Transport
Roads & Maritime
Services

Our Reference: SYD16/00625/10
(A23360272)
DP&E Ref: SSD 7684

**NOTIFICATION OF RESPONSE TO SUBMISSIONS
COCKLE BAY WHARF (SD 7684)**

AMENDED CONCEPT PROPOSAL SSD7684 - STAGED REDEVELOPMENT OF COCKLE BAY WHARF - 241 – 249 WHEAT ROAD, COCKLE BAY DARLING HARBOUR

Figure C1

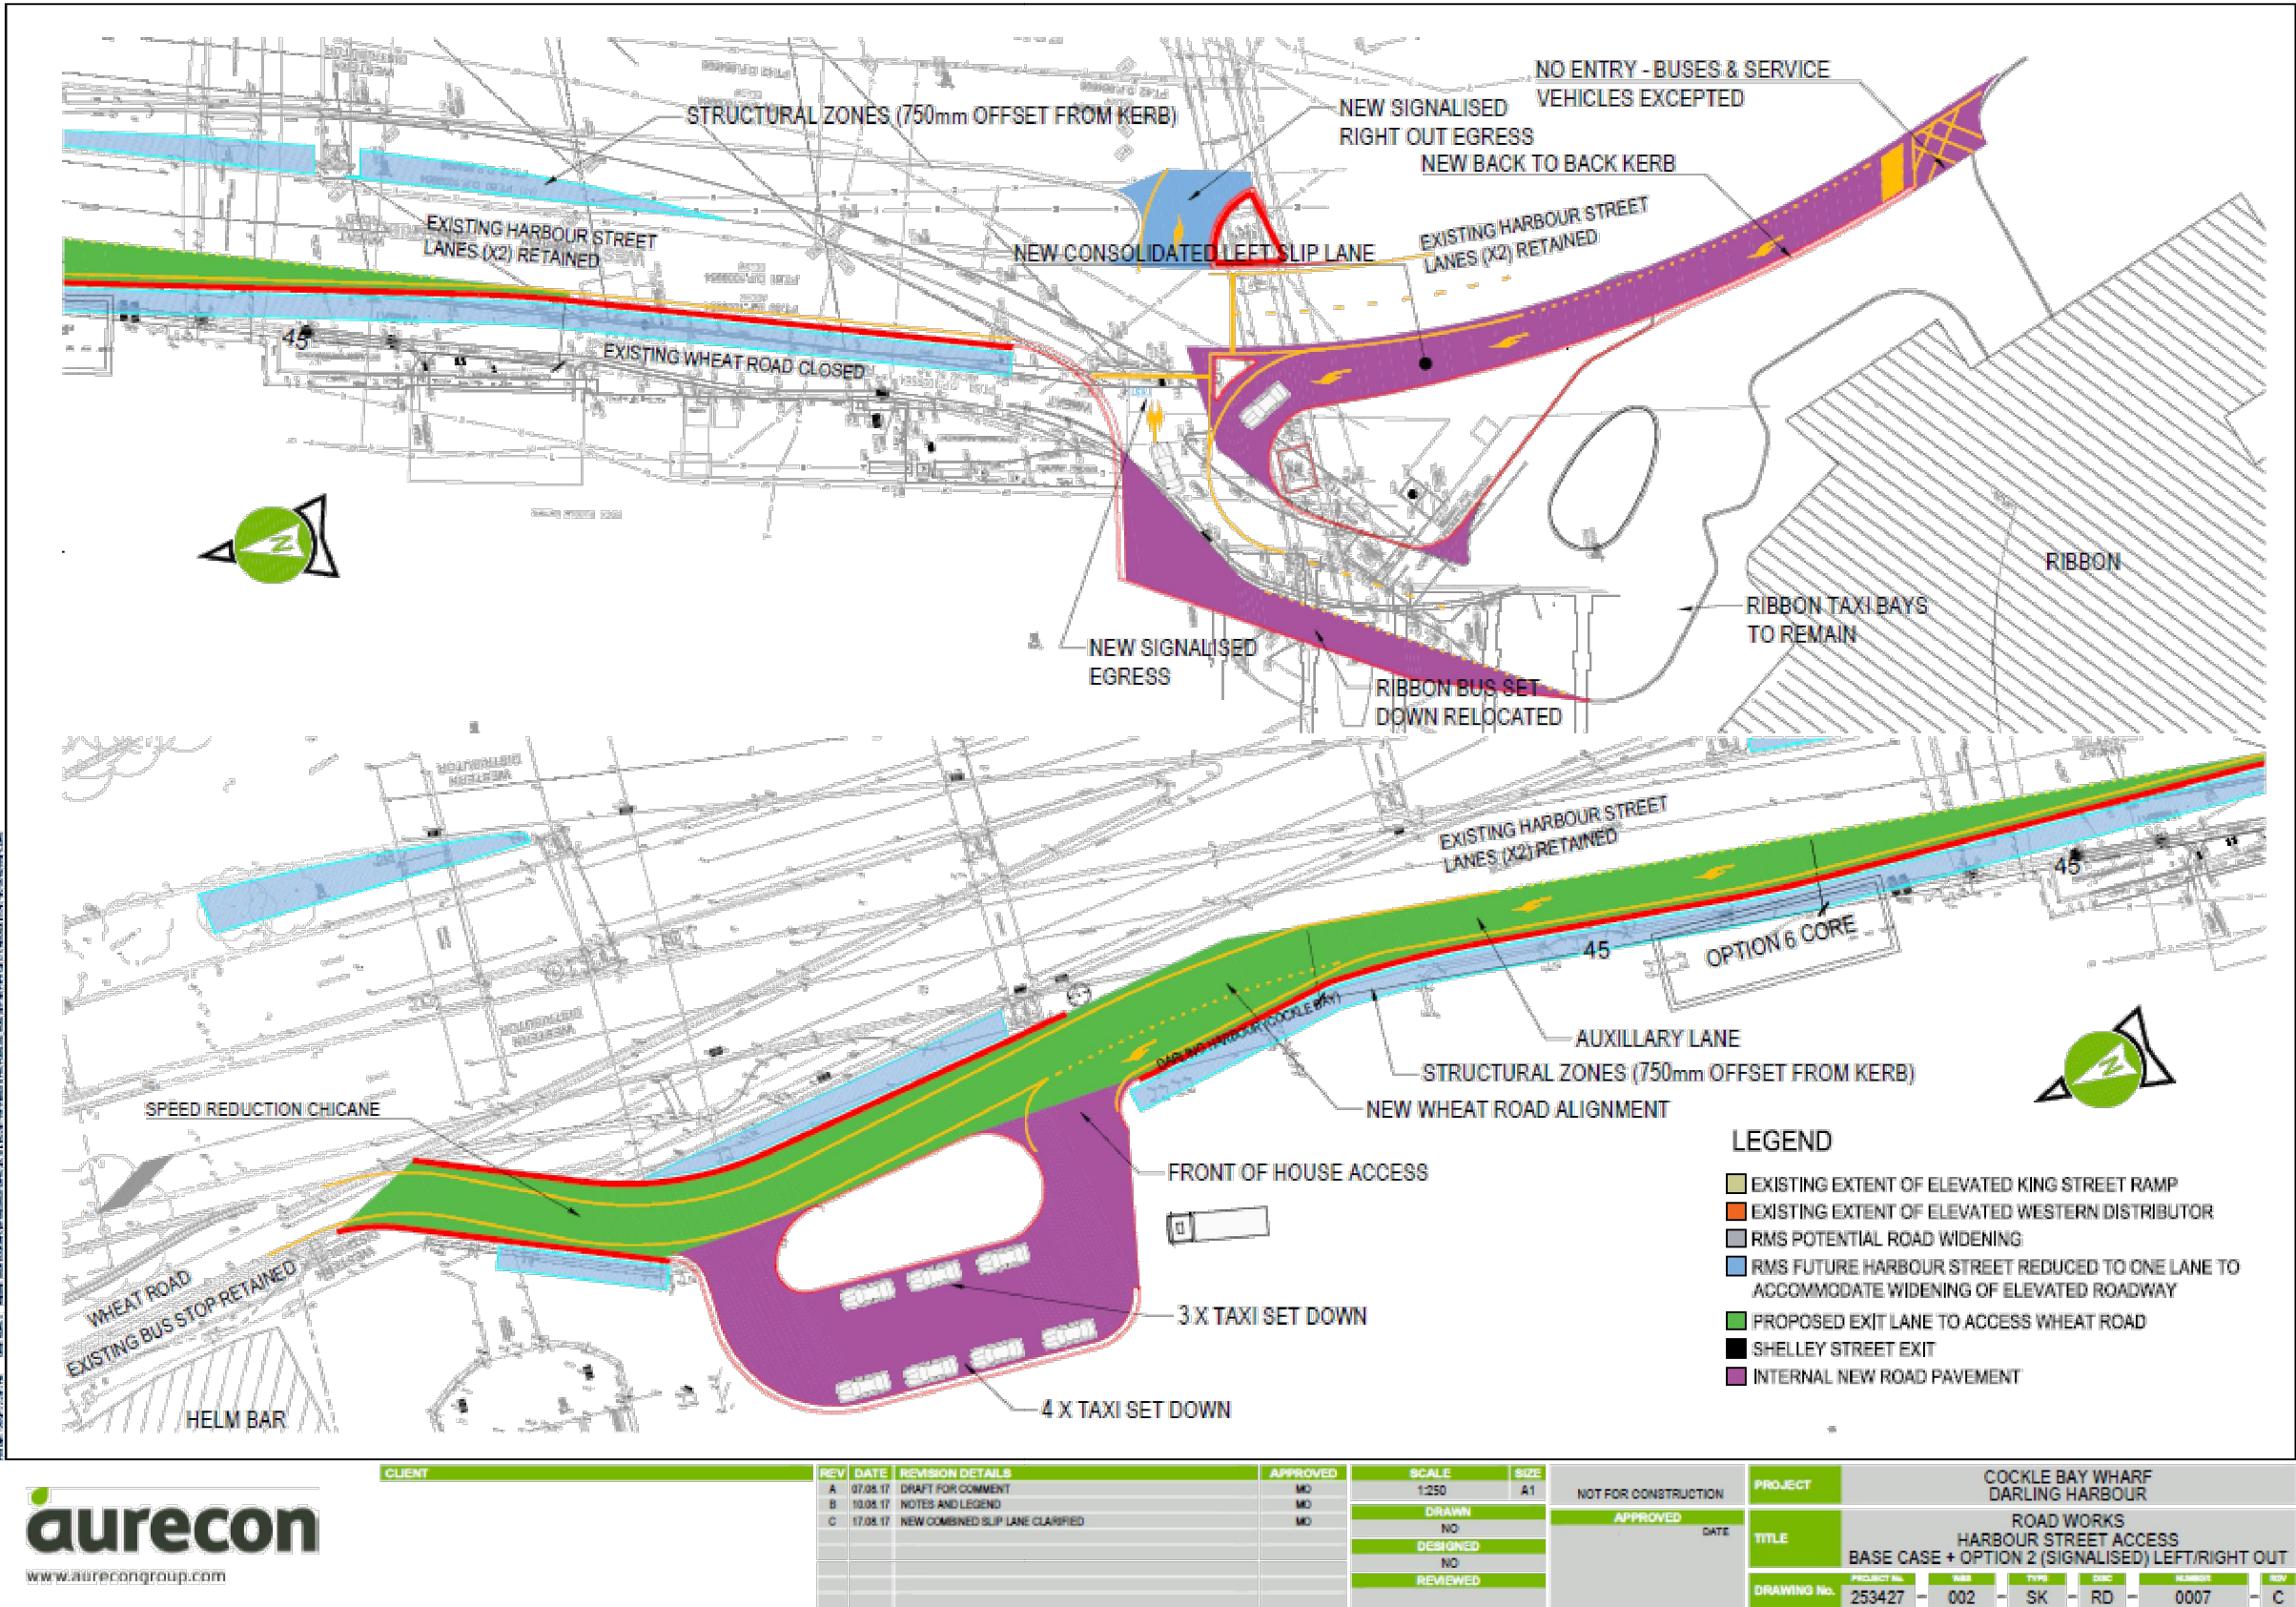
16. Wheat Road and Vehicle Access to the development site - Roads and Maritime has a number of concerns with the proposed right turn on the western approach at the signalised intersection of Harbour Street and Blackwattle Place, shown in Option 2 of the Traffic Report dated September 2017. In this regard the following comments are provided:

In their current state the traffic signals at the intersection of Harbour Street and Blackwattle Place have almost no impact to traffic along this critical corridor. Adding an additional leg on the western approach will alter this scenario.

- ii. As shown in current reports prepared by the Proponent, traffic from the new approach is relatively light and well below Roads and Maritime traffic volume warrants for traffic signals. This raises questions of the necessity of installing a signalised right turn, particularly given the importance of the corridor and the fact that alternative options are available for traffic leaving the development and heading south via the Kings Wharf precinct.
- iii. The level of storage provided on the approach is relatively short. As taxis and point-to-point services accessing Darling Harbour may see this area as a convenient pick up/drop off location, traffic is likely to exceed predicted volumes. This may result in queueing on the approach back into the Ribbon development, possibly extending onto Harbour Street.

- iv. In addition, Roads and Maritime is currently investigating a Smart Motorway through this corridor and if approved is likely to necessitate Ramp Metering on Harbour Street. This will further complicate this heavily trafficked area.
- v. In light of the above, Roads and Maritime does not support the alteration of traffic signals on Harbour Street at Blackwattle Place to facilitate right turning vehicles exiting the development via a new western approach and would not grant consent to the works under Section 87 of the *Roads Act 1993*. Roads and Maritime would raise no objection to the addition of a priority left-turn only exit with Give Way control.
